Coles
166
Littlehampton Road
Ferring
BN12 6PH

Please ask for: Nicola Moore
Email: nicola.moore@arun.gov.uk
Telephone: Ext 37944
Our Ref: FG/8/21/T
Your Ref:
Date: 25th January 2021

Application for Works to Trees(s) subject to a Tree Preservation Order(TPO)

Development: Hornbeam -(#1) - Crown lift lower canopy to approximately 3m on 166 Littlehampton Rd boundary, not exceeding diameter of 100mm.

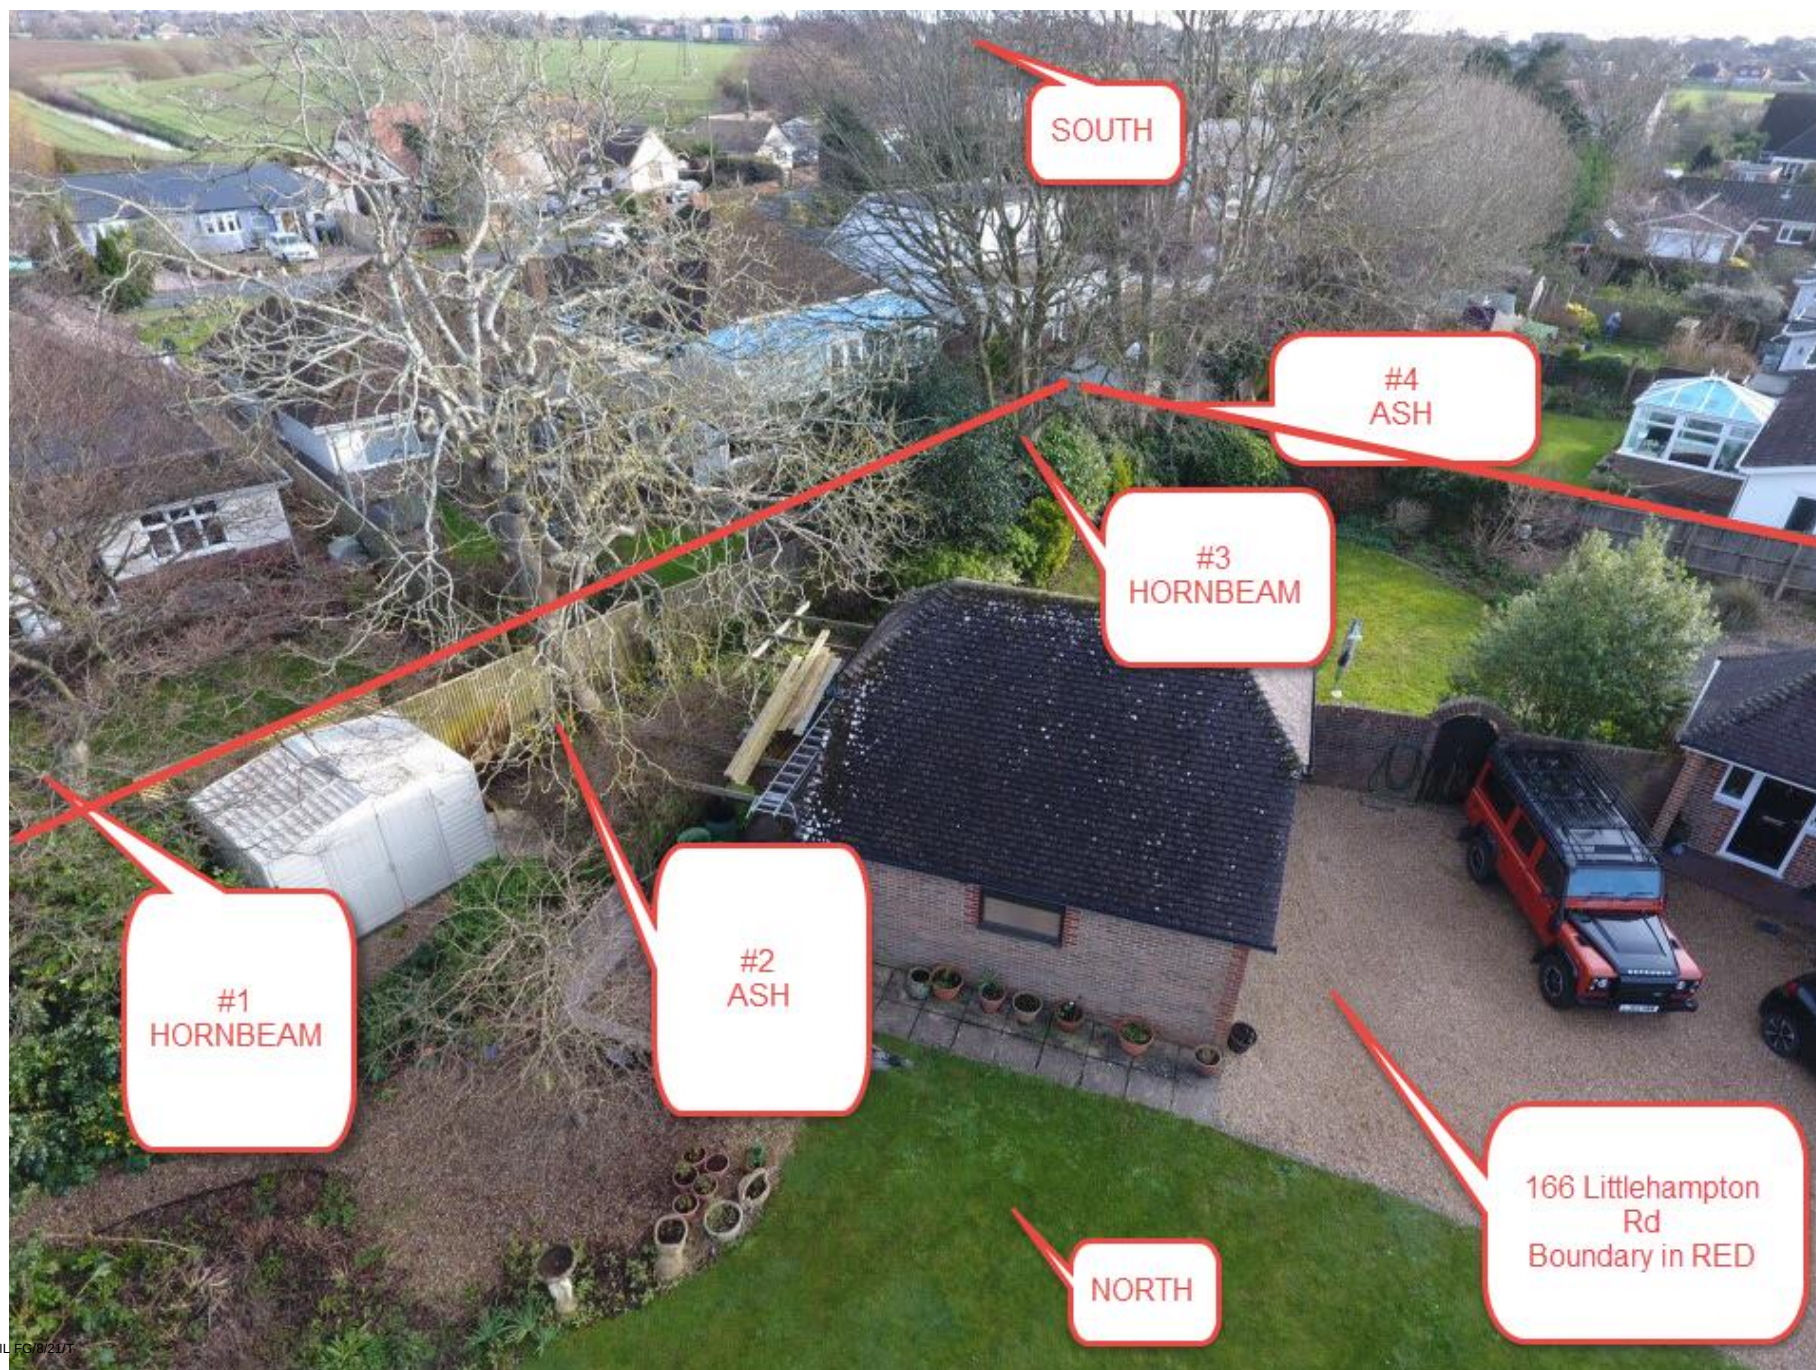
Please provide the proposed lateral spread measurement, in metres, of 1 No. Ash tree.
